KIRKLEES METROPOLITAN COUNCIL INVESTMENT & REGENERATION SERVICE

DELEGATED DECISION TO DETERMINE APPLICATIONS FOR CONSENT, AGREEMENT OR APPROVAL REQUIRED BY CONDITION

Reference No:	2026/44/90405/W
Site Address:	Land south of railway line, Scar Lane, Milnsbridge, Huddersfield, HD3 4PN
Description:	Discharge of conditions 3 (noise assessment), 5 (Phase I Desk Study Report), 6 (Site Investigation Report), 7 (Remediation Strategy), 15 (foul, surface, land drainage), 16 (seperate drainage systems) and 17 (surface water drainage) on previous permission 2024/91381 for variation of condition 2 (plans) on previous permission 2022/91789 for erection of four industrial units for E(g)(iii) (light industry) use with associated parking and turning facilities with 10 storage units
Recommending Officer:	Katie Chew

Officer Report

Figure 2.1 Site measurement positions (Image Source: Google Maps)

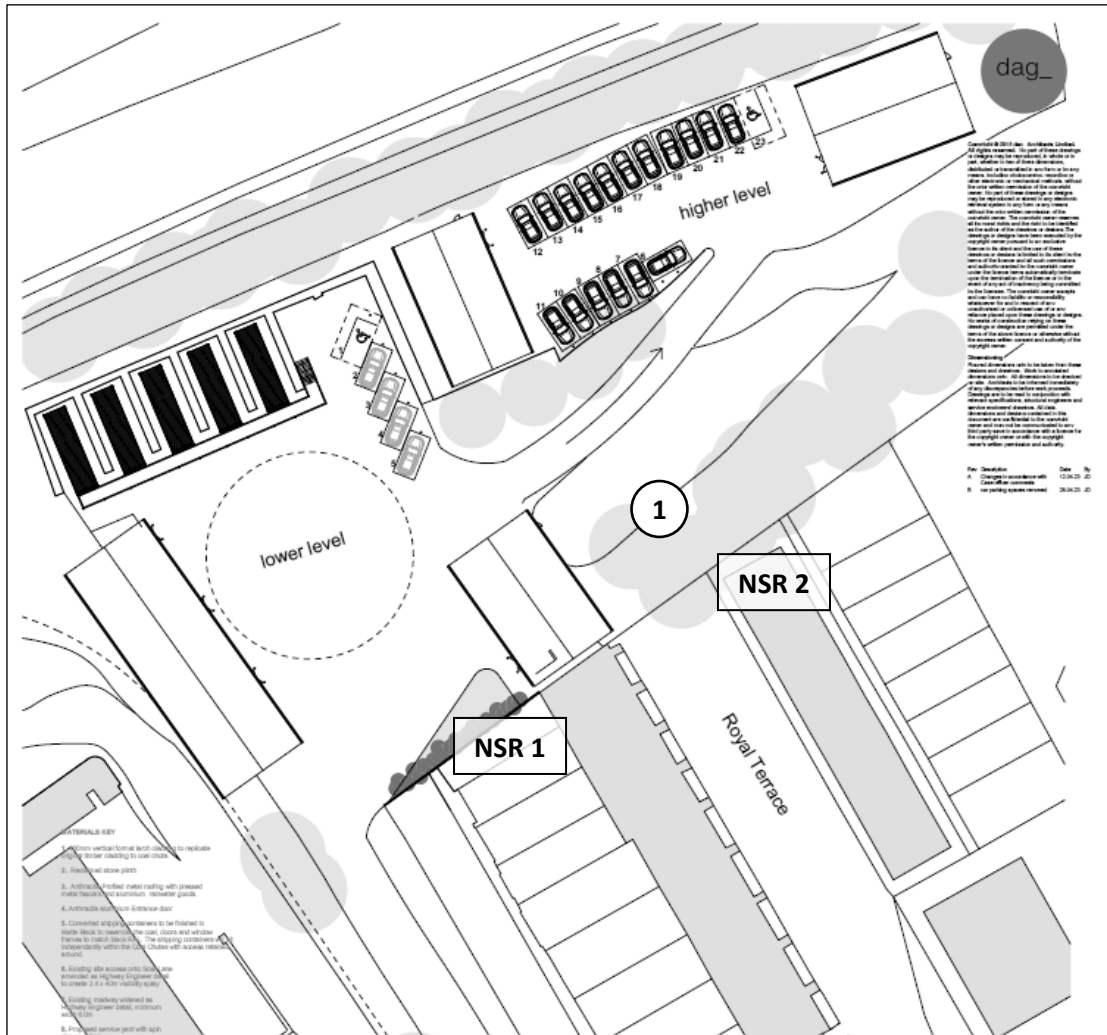
A baseline environmental noise measurement survey was undertaken between 15:00 on 22/11/2023 and 18:00 on 25/11/2023 to establish the noise climate currently experienced across the site. Whilst on site, the surveyor identified that:

the background noise profile at the monitoring location was driven by distant road traffic, with noise from passing trains dominating intermittently. Intermittent but frequent noise was also clearly audible from nearby industrial uses, including dumping of materials and operation of heavy machinery.

The BS4142 assessment has predicted future operational noise levels to include passenger vehicles (cars) x20/hr, light commercial vehicles x3/hr and operational noise breakout with shutters open (as a worst case assumption), and has predicted noise levels at the nearest noise

sensitive receptors NSR 1 and NSR2 to be 43 dB LAeq,1h and 42 dB LAeq,1h respectively, which is below the current background noise level.

The fixed plant levels suggested are at background sound level which would not result in significant noise impacts, however, in order to protect the amenity of nearby noise sensitive receptors at night, we recommend a nighttime noise limit of 5dB below background in order to prevent background noise creep.

The submitted noise assessment satisfies the requirements of condition 3 (noise assessment), and the condition can now be discharged.

FIGURE B: ELEVATED CONTAMINATION LOCATIONS

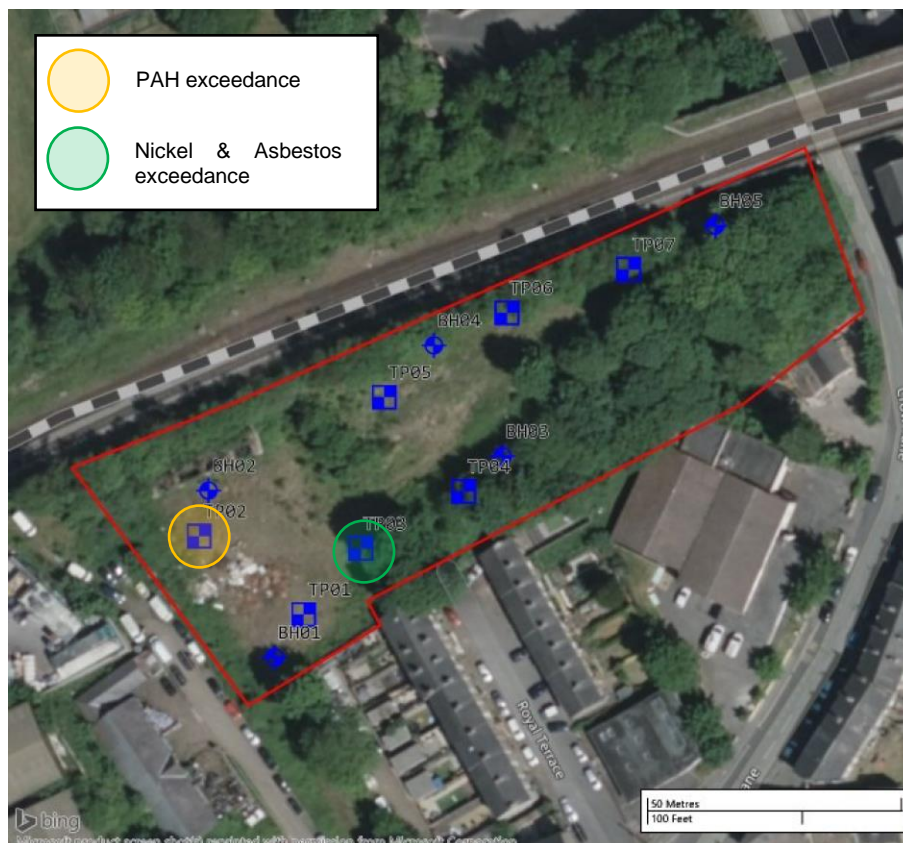
- *“Significantly elevated concentrations of Nickel were encountered in TP03 (1.00-1.10m), in the centre of the site.*
- *Soluble sulphates (potentially aggressive to foundation concrete) were recorded between 61 and 410mg/l.*
- *TP02 – 0.10-0.20m recorded elevated benzo(b)fluoranthene, benzo(a)pyrene, dibenz(a,h)anthracene and total PAH*
- *TP03 – 1.00-1.10mbgl Chrysotile (white) comprised 0.005% asbestos fibre by mass”*

“The below exceedances were noted within the six samples tested:

- TP02 - 0.10-0.20m (Made Ground – granular) recorded elevated benzo(b)fluoranthene, benzo(a)pyrene, dibenz(a,h)anthracene and total PAH*
- TP03 - 1.00-1.10m (Made Ground – granular) recorded elevated levels of nickel and asbestos (chrysotile, quantified as 0.005%)”.*

The report goes on to outline the general remediation strategy, which is considered acceptable, and confirm the requirements for the site contractor to maintain records including volumes of materials, waste disposal records, surveys for base digs etc.

The submitted information is considered acceptable for the purposes of discharging conditions 6 and 7, namely:
